Ribble Valley Borough Council
Council Offices
Church Walk,
Clitheroe
Lancashire
BB7 2RA

Phone: 0300 123 6780
Email: developeras@lancashire.gov.uk
Your ref: 3/2025/1007
Our ref: 3/2025/1007/HDC/KW
Date: 26 February 2026

Location: 1 The Acres Barrow BB7 9BH
Proposal: Proposed conversion of the existing dormer bungalow into a two-storey dwelling by removing the current roof, raising the walls and constructing a new roof to create a larger, full first-floor level. Erection of a single-storey side extension at the back of the property, demolition of the existing conservatory and replacement with an orangery. Construction of an extended front entrance.
Grid Ref: 373955 437933

| EXISTING AND PROPOSED SITE PLAN | | |

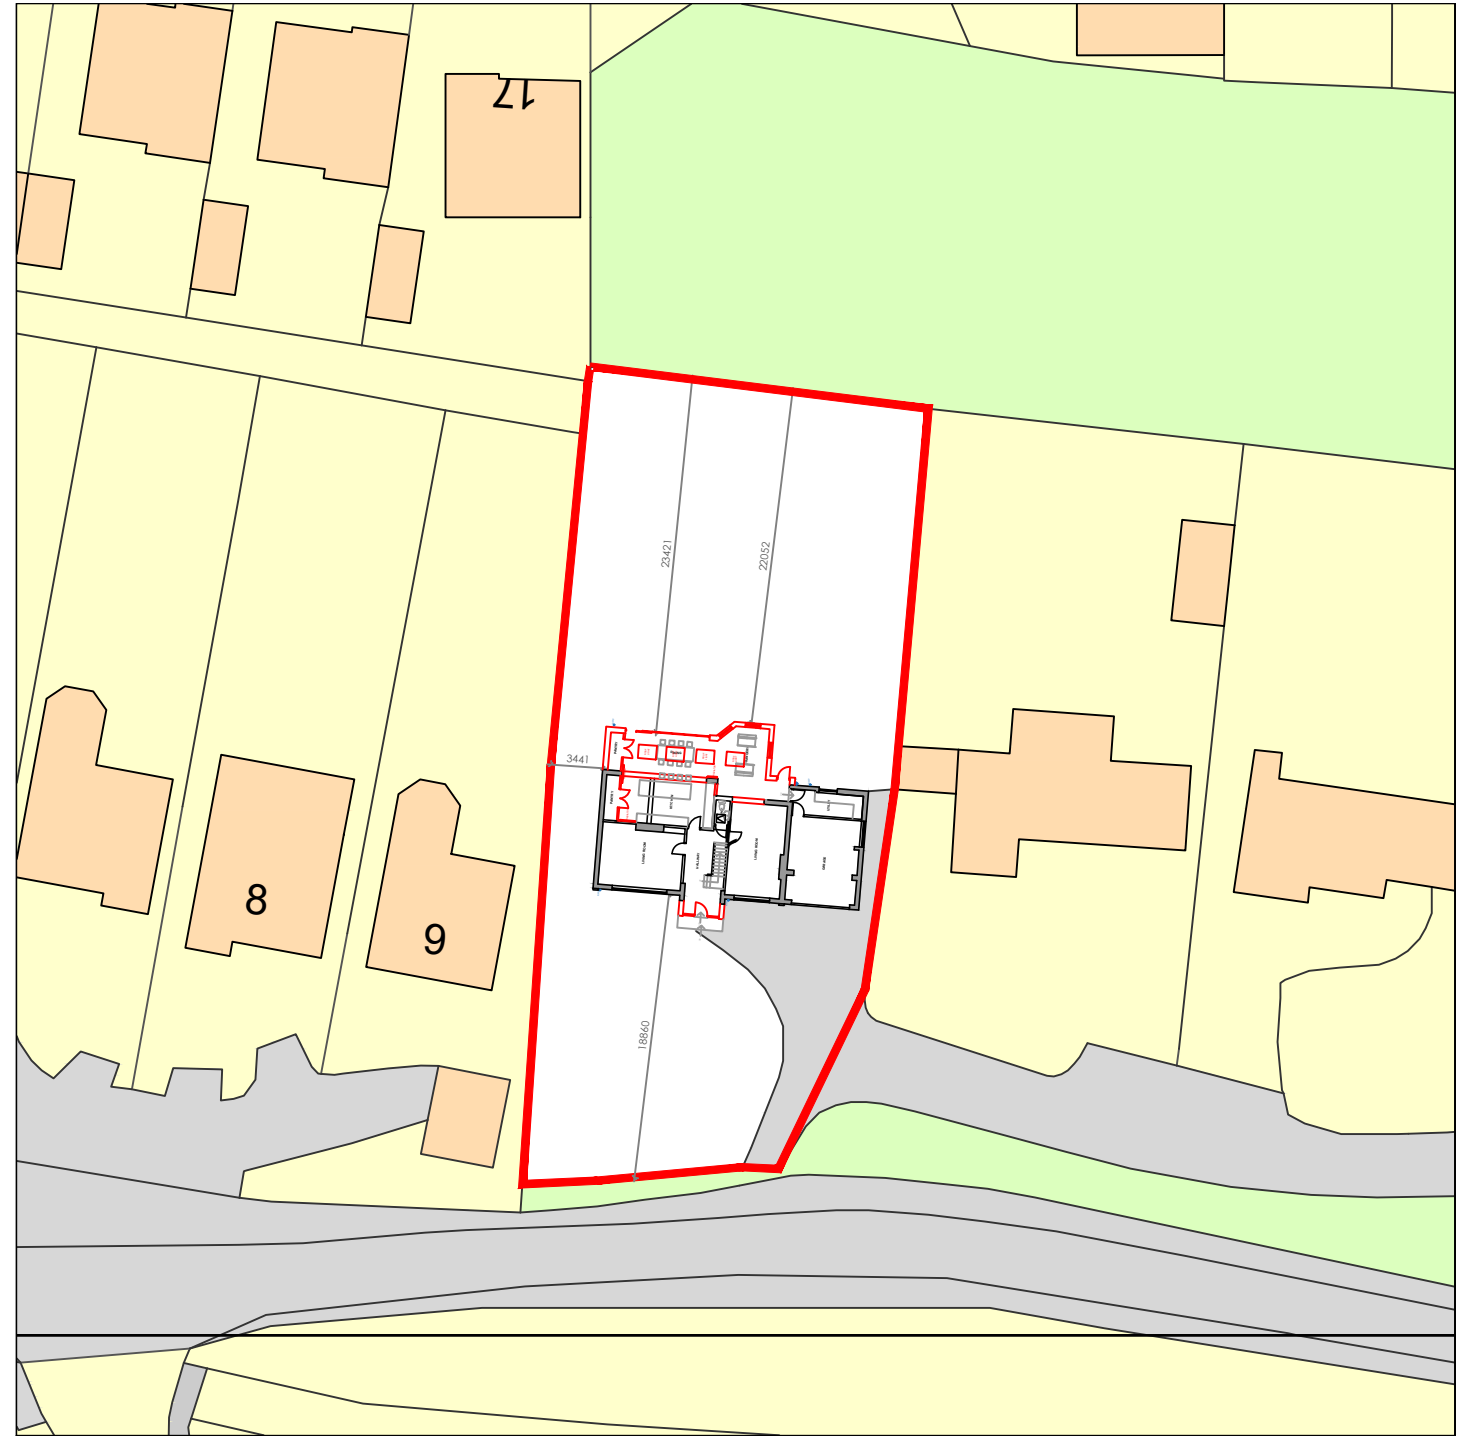
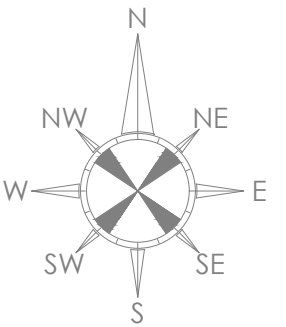
The LHA have reviewed drawing number 2025/06 titled "Existing and Proposed Site Plan" and are aware that the dwelling complies with the LHAs parking standards as defined in the Joint Lancashire Structure Plan. Therefore, the LHA have no objection to the proposal.

The existing garage will be retained, although it does not meet the recommended dimensions for a single garage size, which is 6m long and 3m wide. The recommended distance of 6m is based on the length of a large family car (Ford Mondeo Estate 4.58m long), clearance at the rear of the car (200mm), overhang of the garage door (600mm) and room to stand in front of the car and open/close the garage door (600mm). Where garages are smaller than the recommended minimum internal dimension of 6 x 3m they should not be counted as a parking space.
